Recommendation Report for Planning Permission for Works or Extension to a Dwelling

REF NO: FG/1/26/HH

LOCATION: 8 Laburnum Close
Ferring
BN12 5EJ

PROPOSAL: Proposed front extension (to replace existing porch/conservatory), rear extension, new roof tiles and render to cover existing brickwork and loft conversion to include front and rear dormers and removal of barn hips to the side.

Drawing Number: AR-201-02

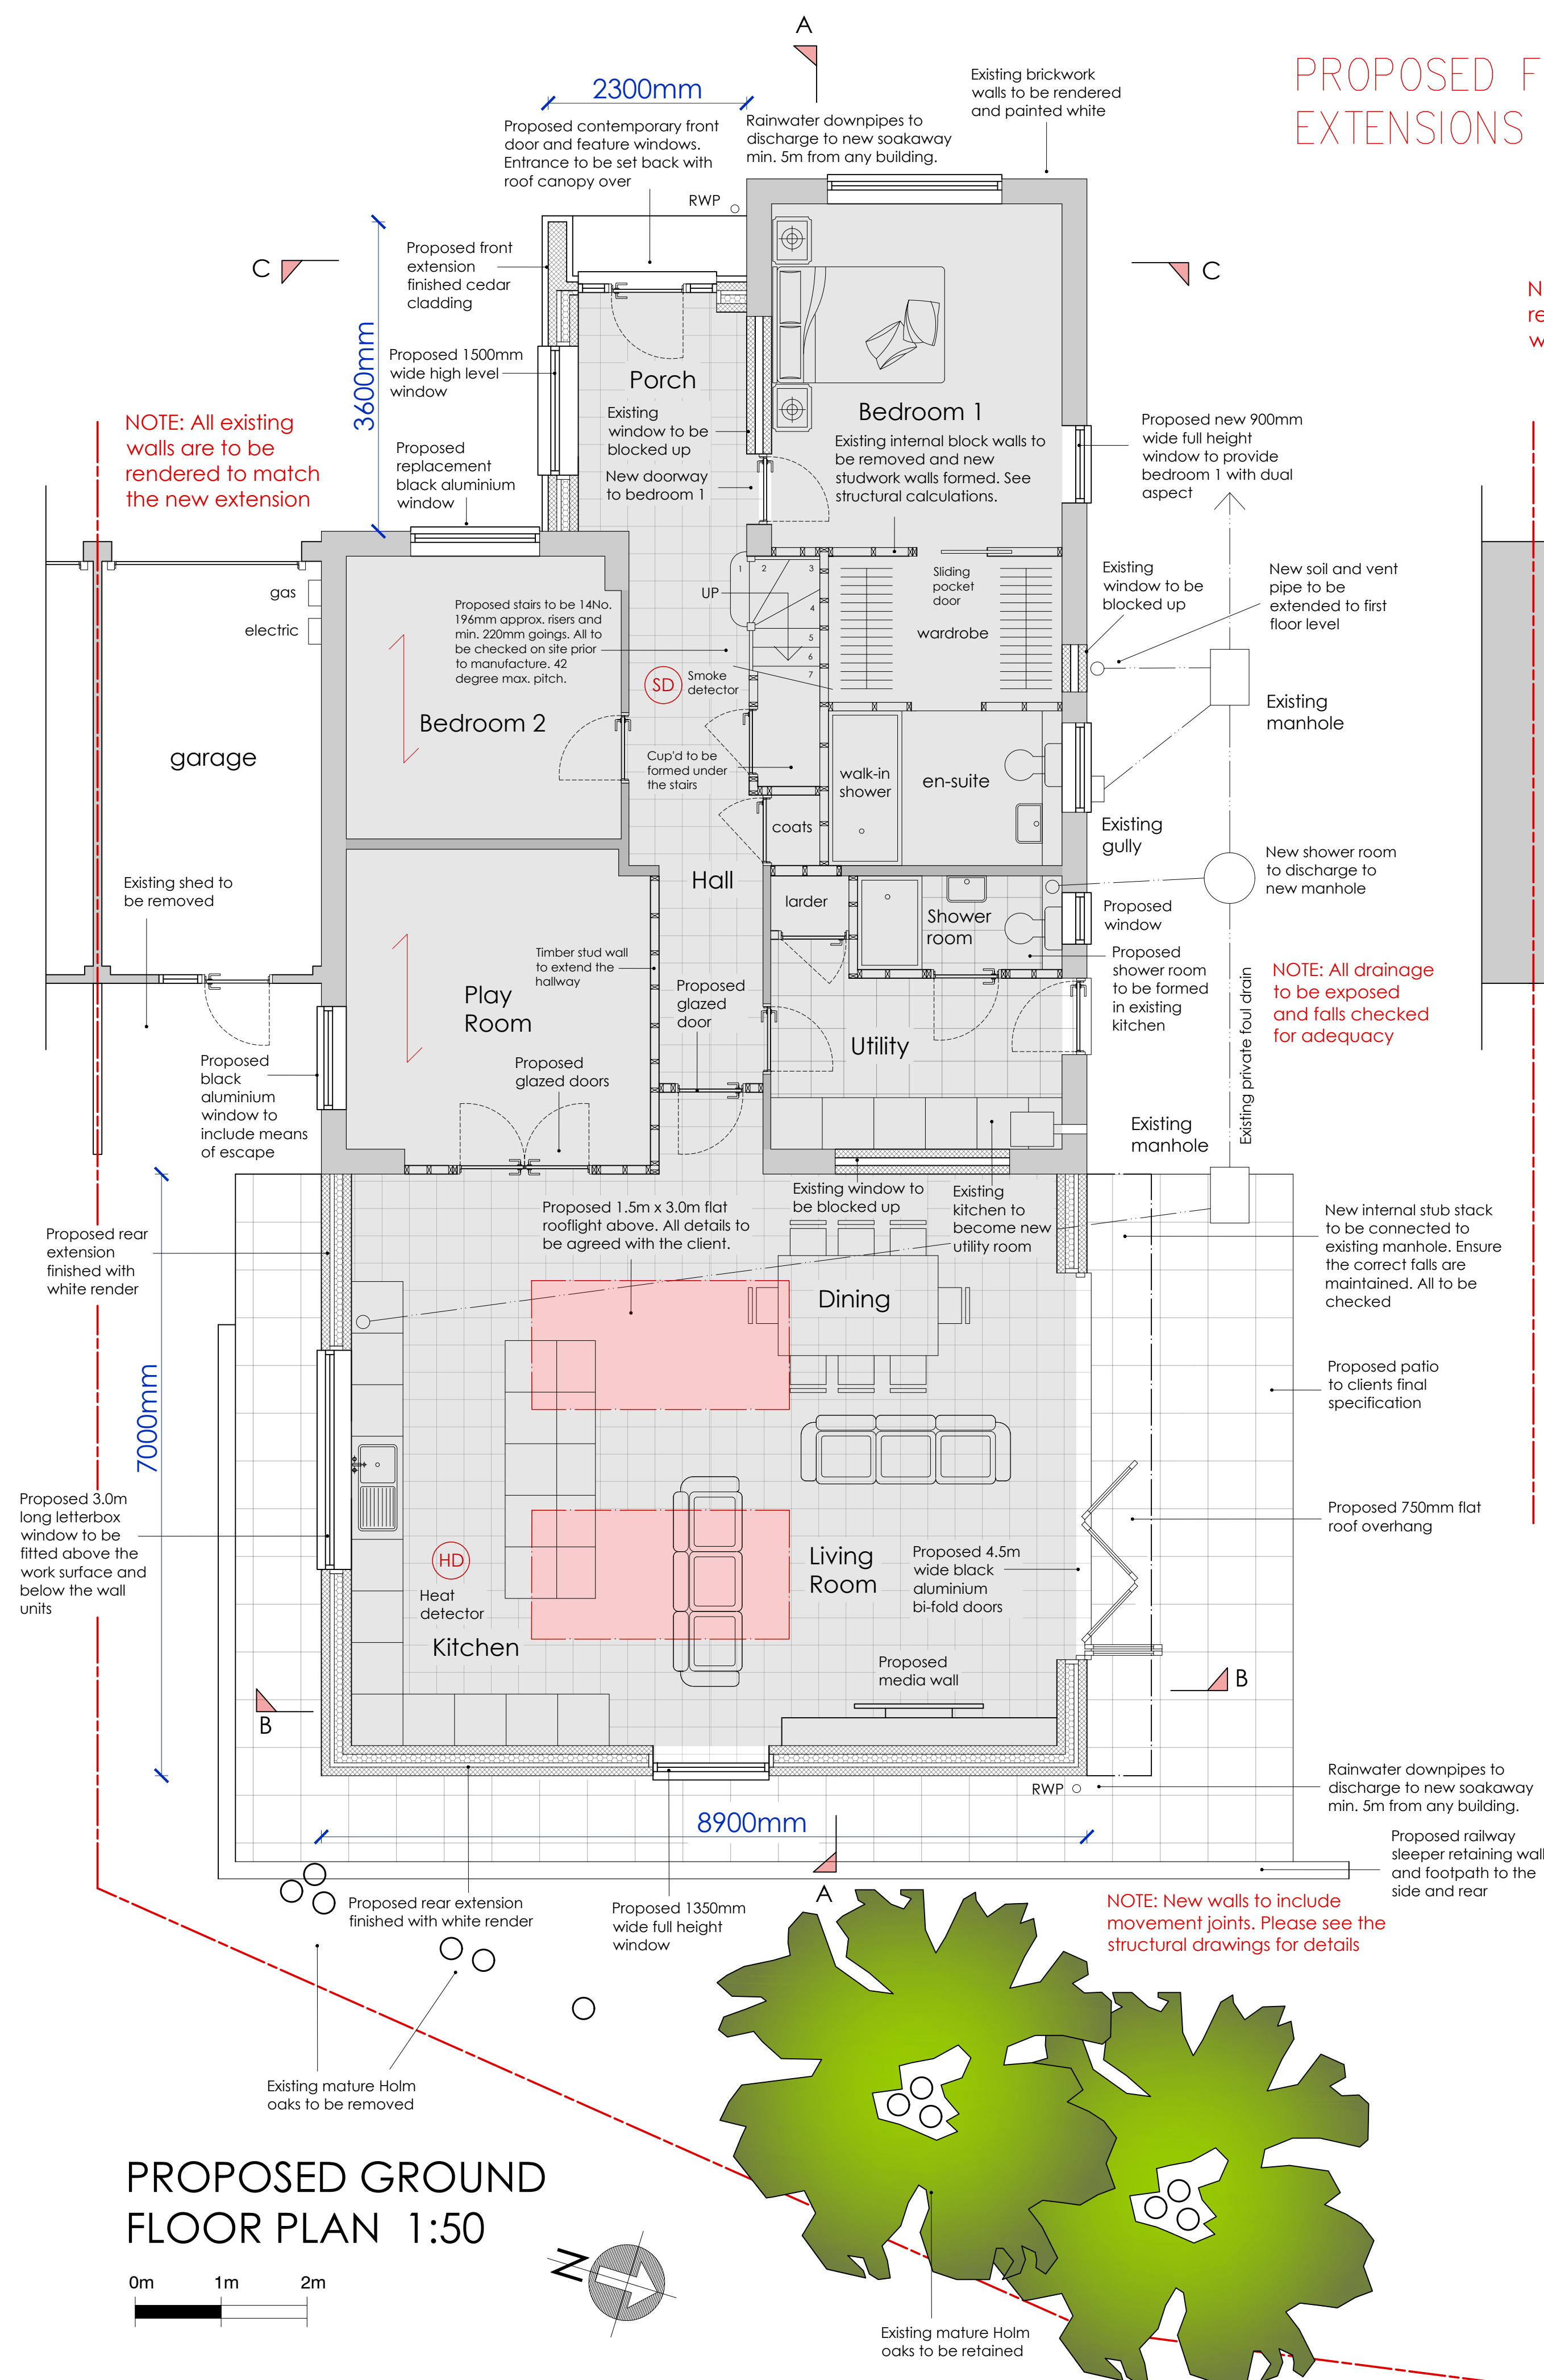
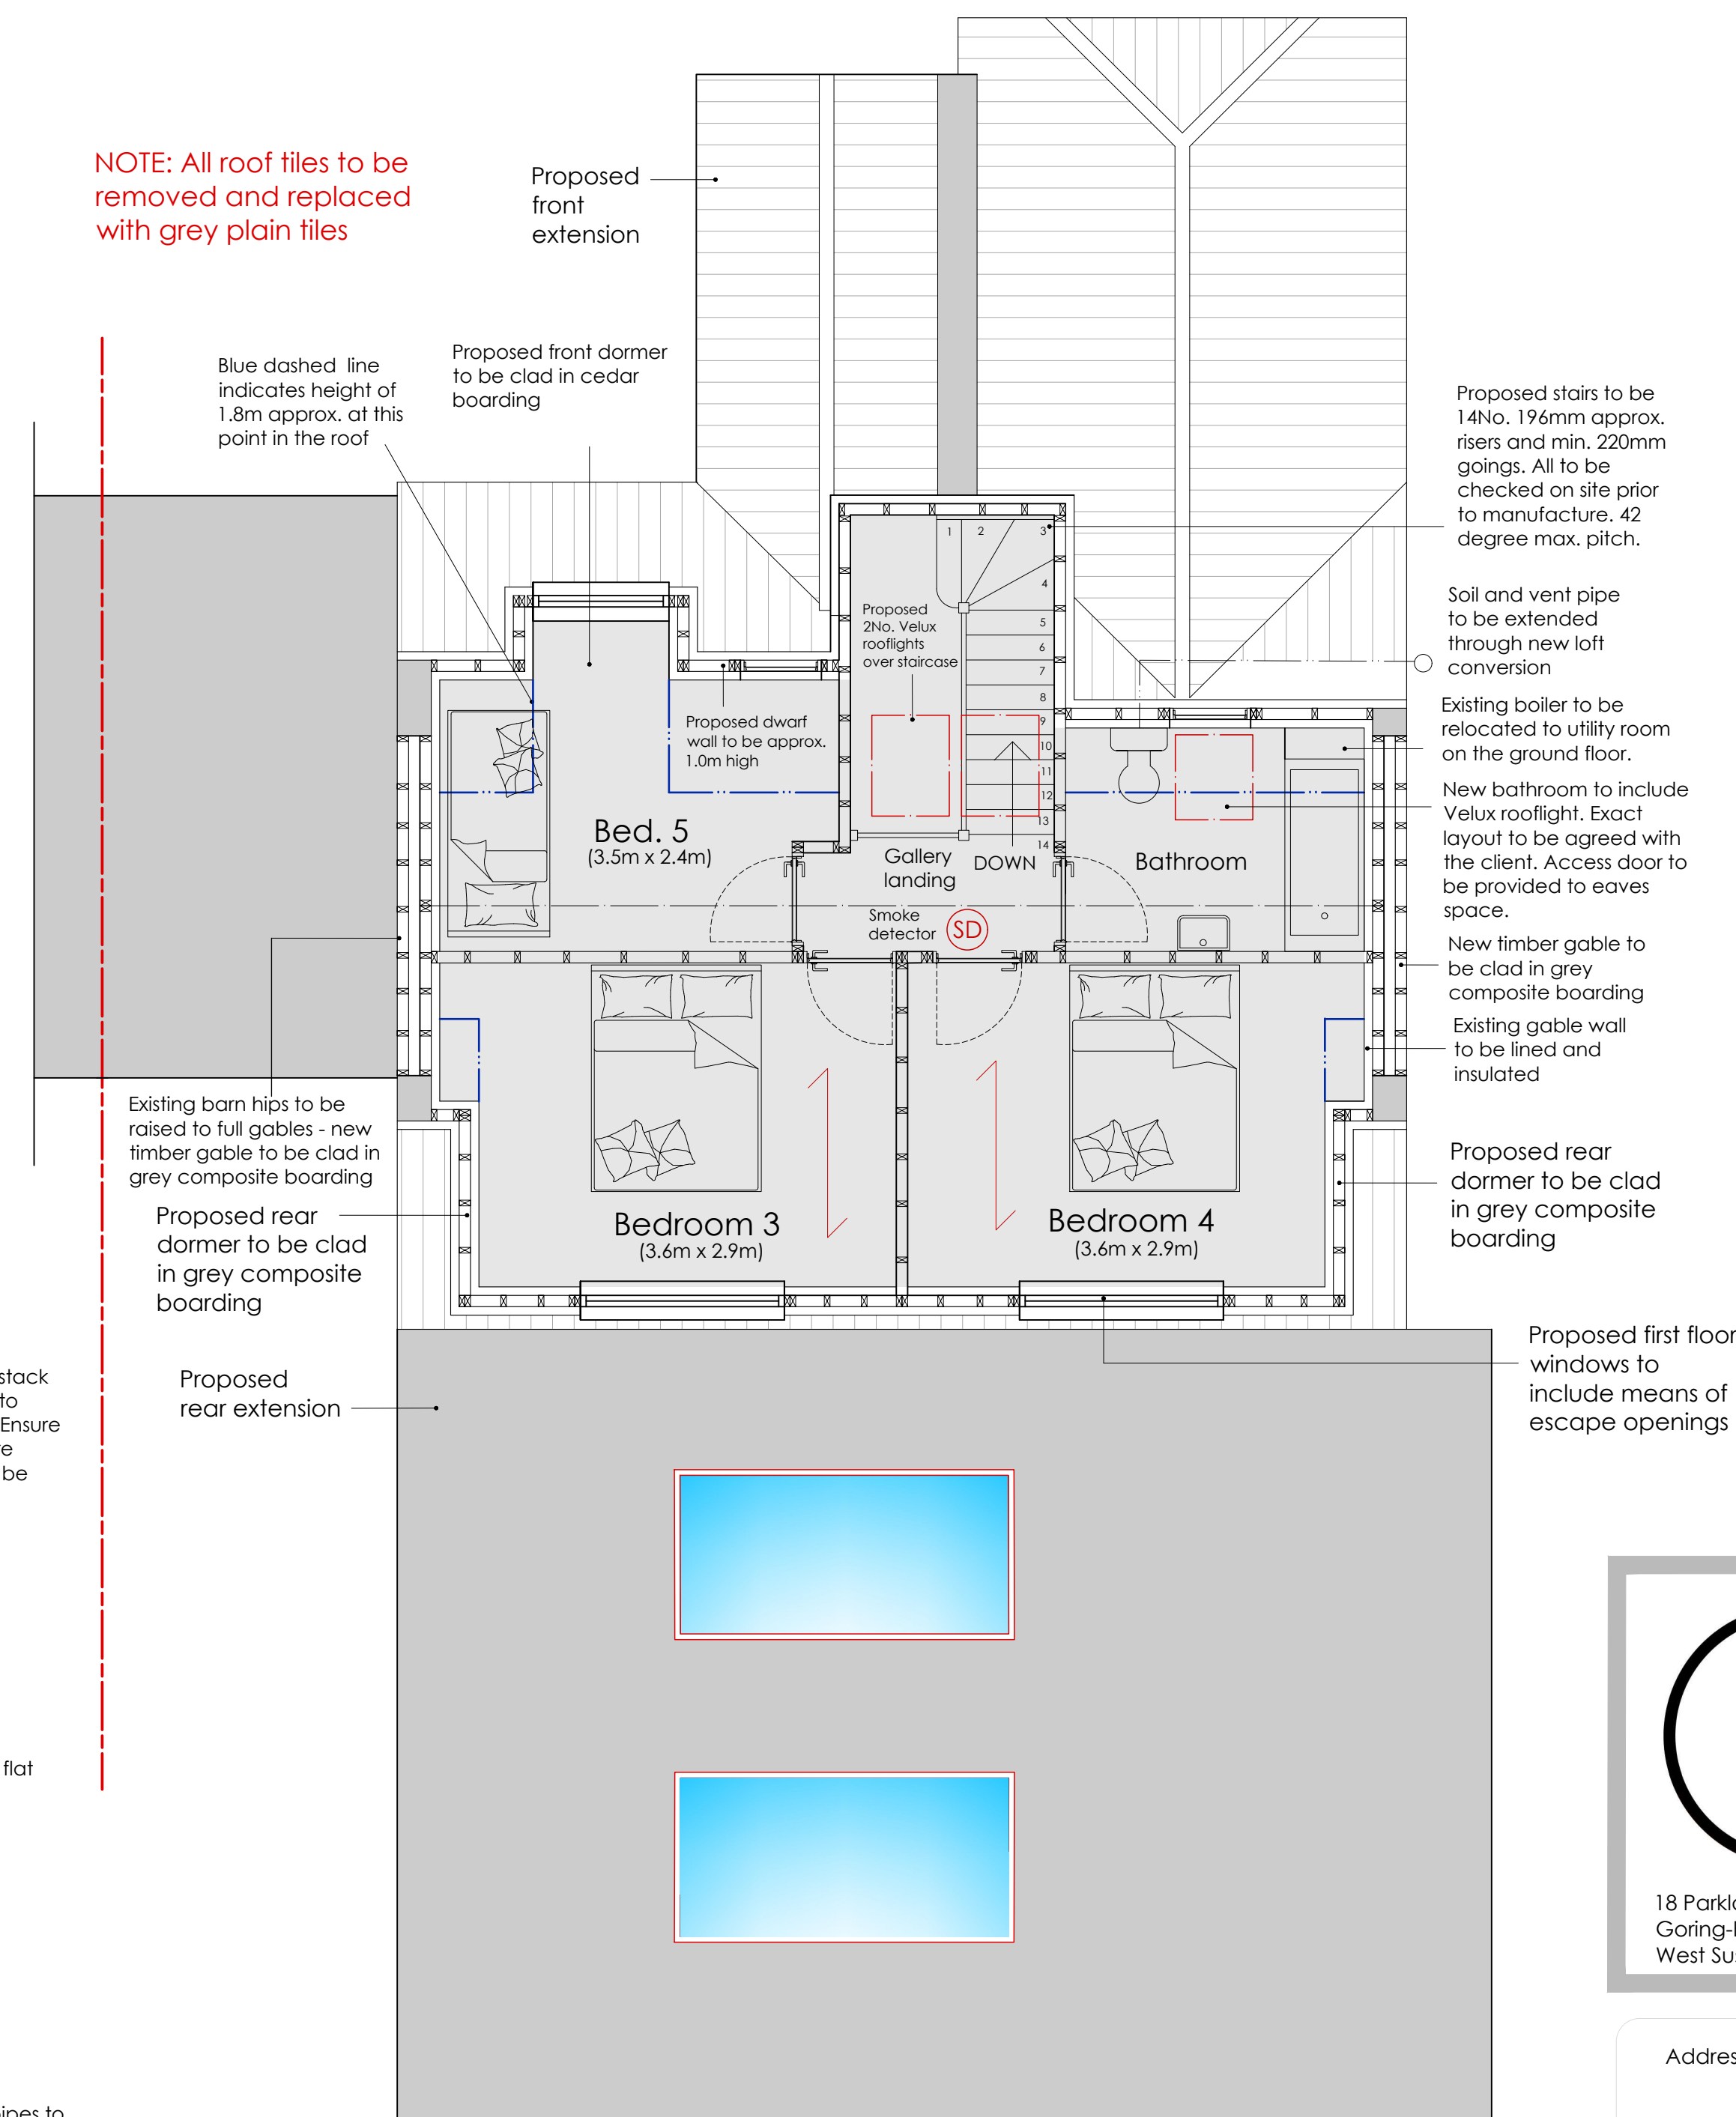
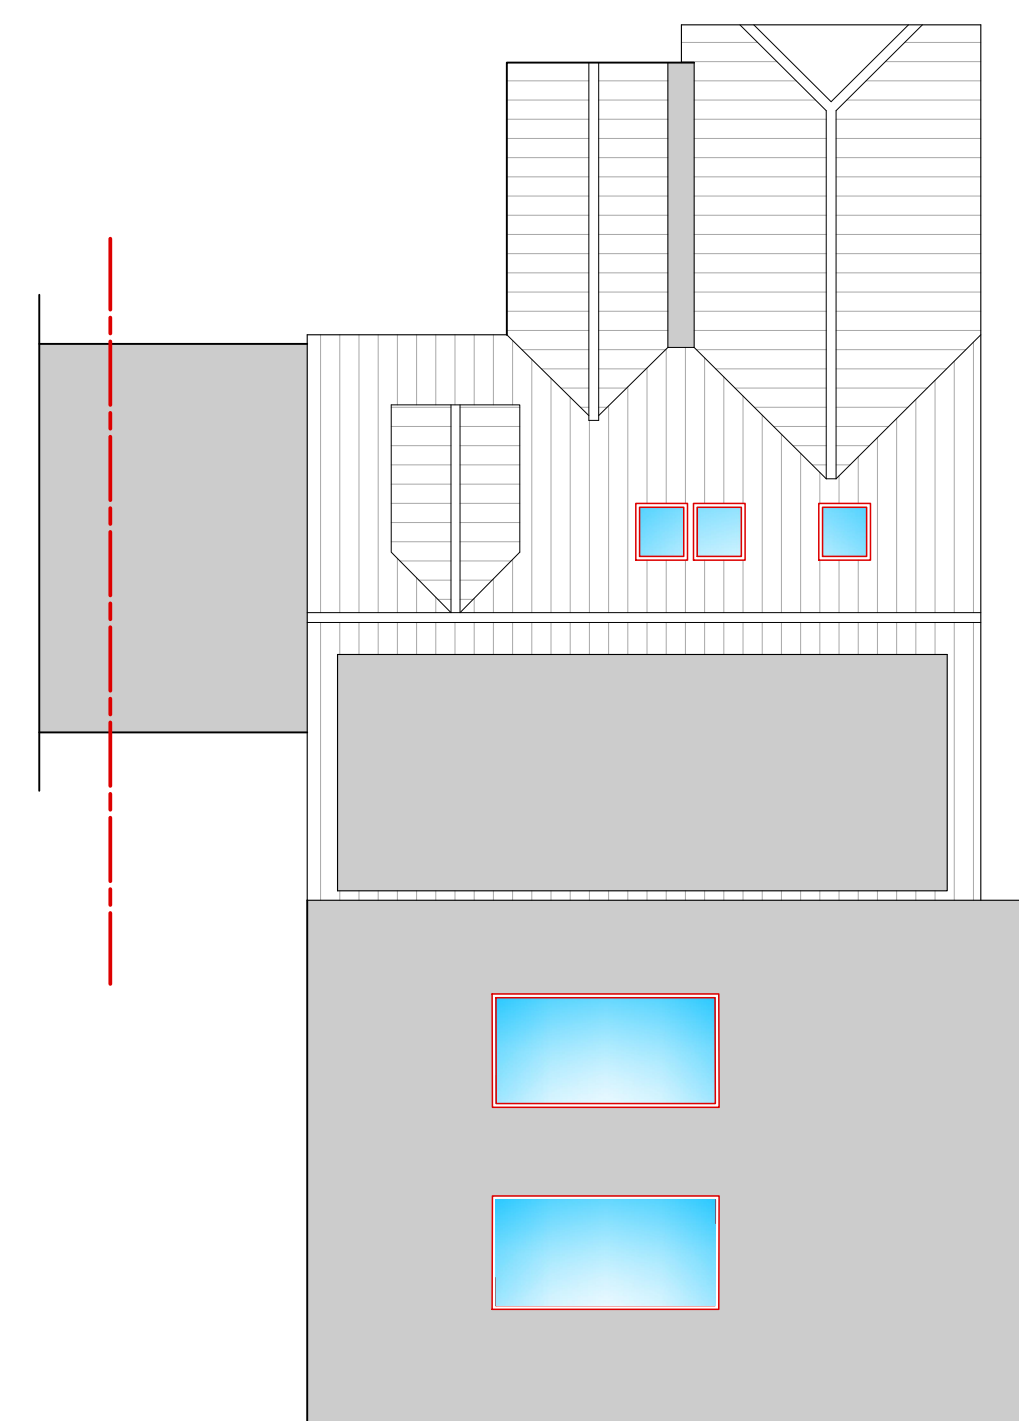
The proposed front extension would measure approximately 2.3m in width and 3.6m in depth, replacing the existing glazed porch. The main entrance would be recessed, creating an open canopy feature. The extension would incorporate a pitched roof form with a maximum height of approximately 4m and an eaves height of 2.5m, finished in grey roof tiles. It is noted that the depth of the proposed front extension would exceed the guidance depth of 1.5m for front extensions outlined within the Arun Design Guide (ADG). Notwithstanding this, the proposed front extension would replace an existing conservatory of a similar depth and scale, and given the variation within the street scene of Laburnum Close, and that the proposed front extension would replace an existing structure, the proposed front extension would not result in demonstrable harm to visual amenity.

The proposed single storey rear extension would measure approximately 8.9m in width and 7m in depth, finished in white render. The extension would have a flat roof form with a maximum height of approximately 3.5m. Although the scale would not appear subservient to the host dwelling, the extension would be positioned to the rear, and would not be visible from the public realm, screened by the 1.8m boundary fencing.

The proposed depth of the rear extension would exceed the ADG guidance, which recommends that the depth of single storey rear extensions should not exceed 3.3m. However, as the extension would be situated to the rear and would not affect the street scene, and the application site would retain a significant amenity space provision to the northern part of the application. As such, this deviation from ADG would be acceptable in this instance.

Fenestration to the rear extension would include a full height window in the eastern elevation, a high level window in the side (southern) elevation, and a large bi-fold door on the side (northern) elevation leading into the side garden. Two rooflights measuring approximately 1.5m x 3m are proposed within the flat roof section.

Alterations are also proposed to the existing fenestration. On the side (north) elevation, new ground floor openings would include a door in a similar position to the existing, a small window, a two-casement window, and an additional full height window serving the existing bedroom. A further window is proposed on the side (south) elevation. The existing shed would be removed, and the garage would be modified to include a glazed door with a small window positioned alongside it. All new windows would be finished in black aluminium to match those proposed for the extensions. The proposed fenestration would be proportionate in number and scale and would not result in harm to visual amenity.

Roof alterations are proposed to convert the loft to habitable space. The existing barn-hipped roof sections would be raised to full gables, aligning with the existing ridge height of 5.9m (from existing eaves height of 4.4m at the barn-hip ends). New dark grey roof tiles are proposed. It is noted that there are no other properties with gabled roof forms within the street scene, however, this alteration could be constructed under permitted development, and it is acknowledged that there is some variation within the street scene with regards to hipped and barn-hipped roof forms. As such, the proposed roof extensions would not result in demonstrable harm to visual amenity.

Three rooflights are proposed within the principal (west) roof slope. While the ADG discourages rooflights on front elevations, similar examples exist within the vicinity and it is noted that front rooflights can be inserted under permitted development. As such, this deviation from ADG would be acceptable.

A small front dormer is proposed on the front (west) elevation, featuring a pitched roof consistent with the existing front projection and new front extension. The dormer would measure approximately 1.7m in width and 2.9m in depth, with a maximum height of 2.3m and an eaves height of 1.1m. It would be finished in cedar boarded cladding and contain a two-pane window. The dormer would be a subservient addition to the front roof slope, and would not appear overly dominant despite there being no other examples within the street scene. As such, given the scale and design of the dormer, the dormer would be acceptable within the context of the site.

A rear dormer is proposed within the rear roof slope elevation, facing east. The dormer would measure approximately 8.2m in width and 3.3m in depth, with a flat roof reaching 2.4m in height. It would be finished in grey composite cladding to complement the proposed roof tiles and would feature two three-pane windows. The rear dormer would be large in scale, and would not be subservient addition within the rear roof slope. The eaves line of the original roof would not be reinstated, and the proposed dormer would instead adjoin the flat roof section of the rear extension. However, it is noted that a rear dormer of comparable scale and volume could be constructed under permitted development, and given the siting of the dormer to the rear, the dormer would not result in demonstrable harm to visual amenity.

It is acknowledged that the proposal would not fully comply with the ADG in terms of garden amenity space, with a remaining depth of approximately 2.2m, below the recommended 10.5m. However, sufficient private amenity space of approximately 14.6m would remain to the side (north) of the extension. The design has been oriented to utilise this space, and overall amenity provision would be adequate for occupiers.
